MEMO

AC-14-00073

Mark Hayden/ Valley Veterinary Hospital

2090 Vantage Hwy

SHEET TITLE:  
 SITE PLAN  
 PRE-APPLICATION MEETING SUBMITTAL  
 SHEET NUMBER:  
**A1.0**

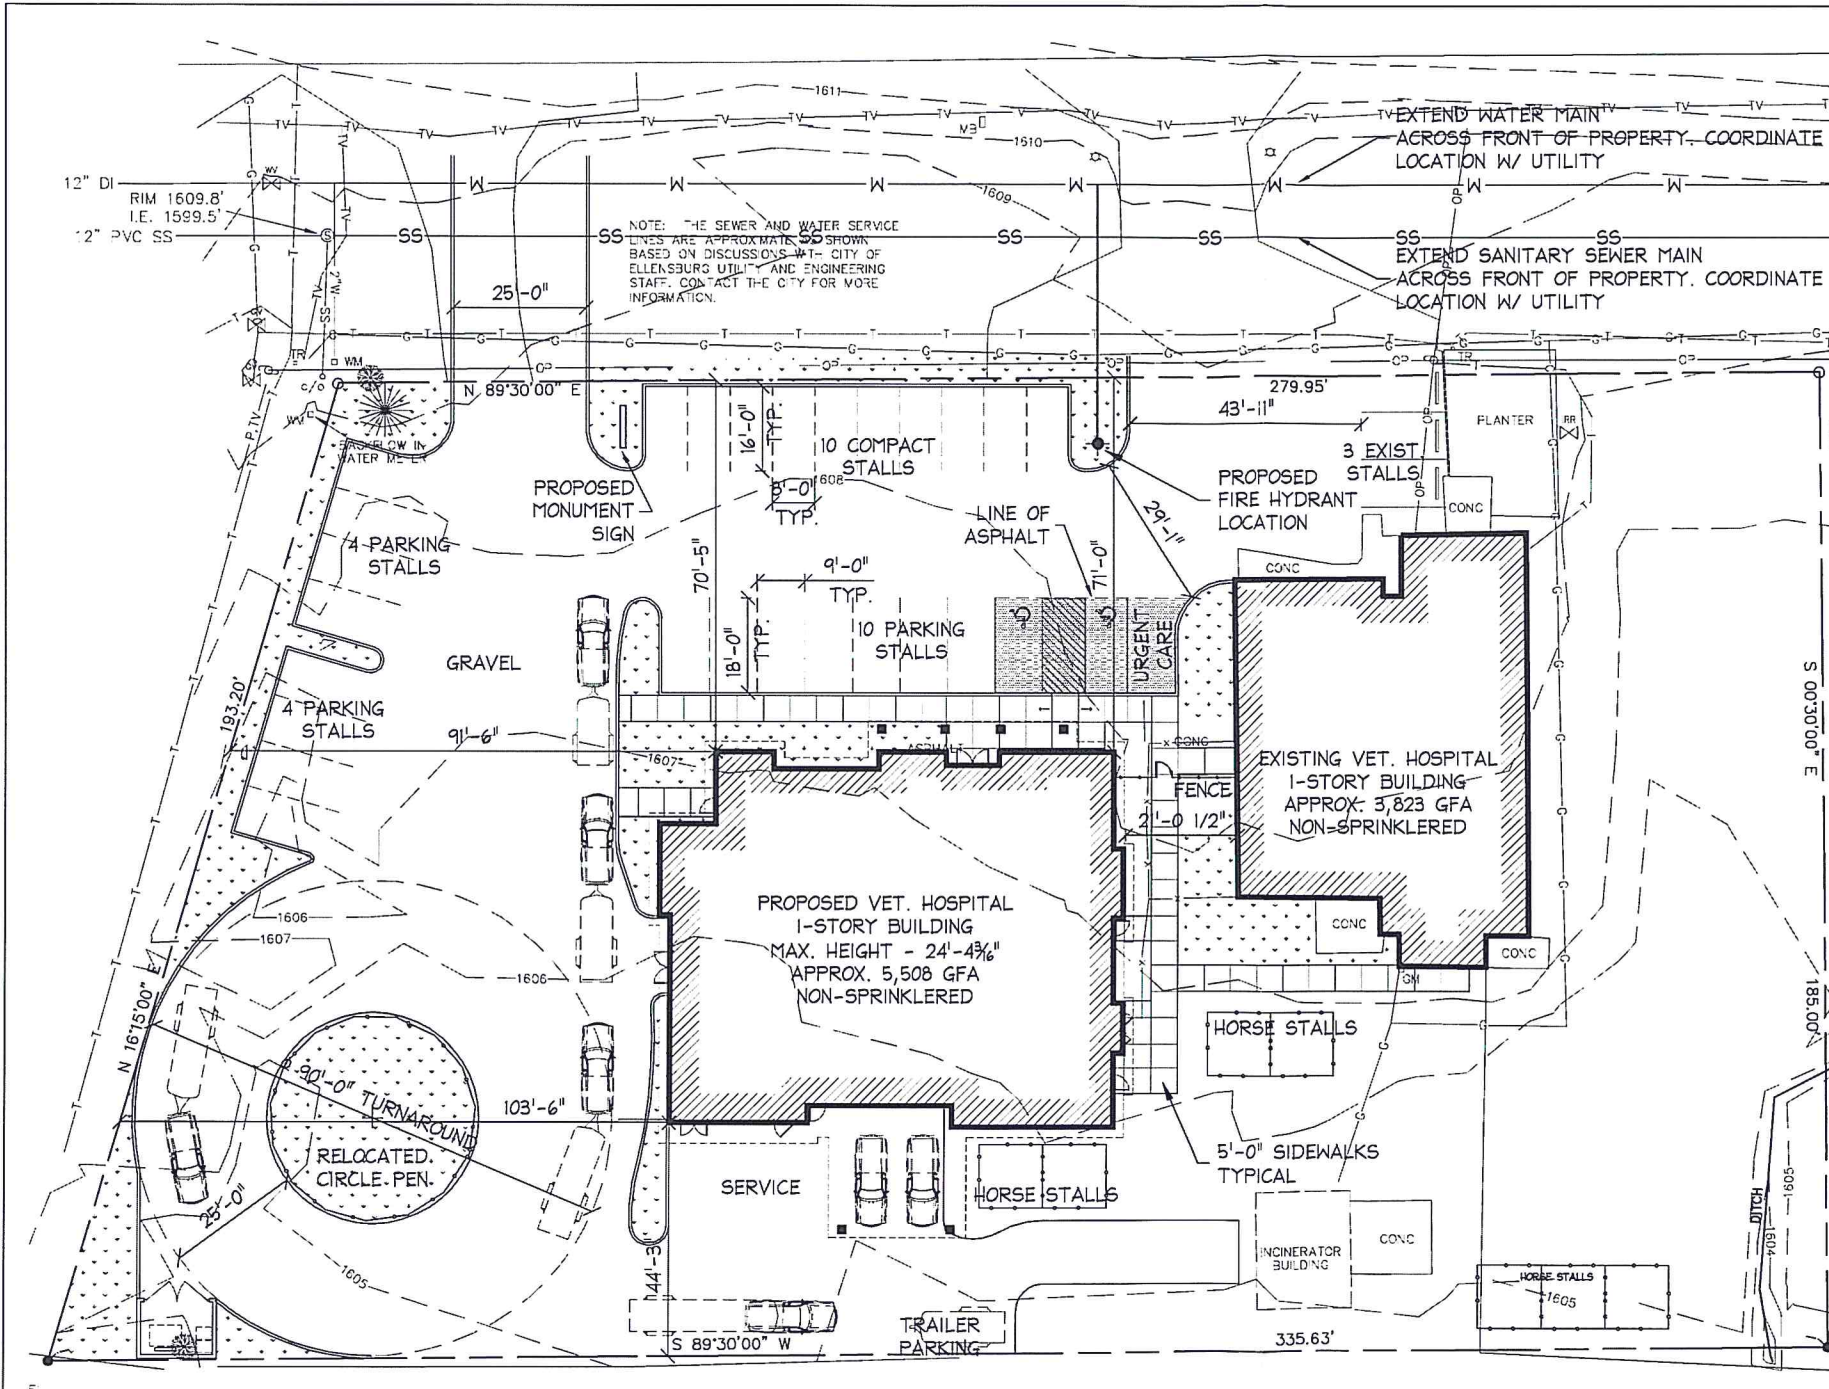
Kelly Bacon and Doug D'Hondt performed an inspection of the improved access approach to map # 17-19-06020-0002. The inspection showed that the turning radius did not meet the approved design turning radius of 30 feet. Kittitas County Public Work is willing to allow a temporary Occupancy Permit under the following requirements:

- 1) Owner is to place a layer of gravel and compact the surface on the sides of the existing access as built. Once this is complete please contact Public Works for an inspection. Once approved, Public Works will sign off on the Temporary Certificate of Occupancy.
- 2) Applicant will have until June 30, 2015 to complete the work needed on the turning radius and contact Public Works for inspection.
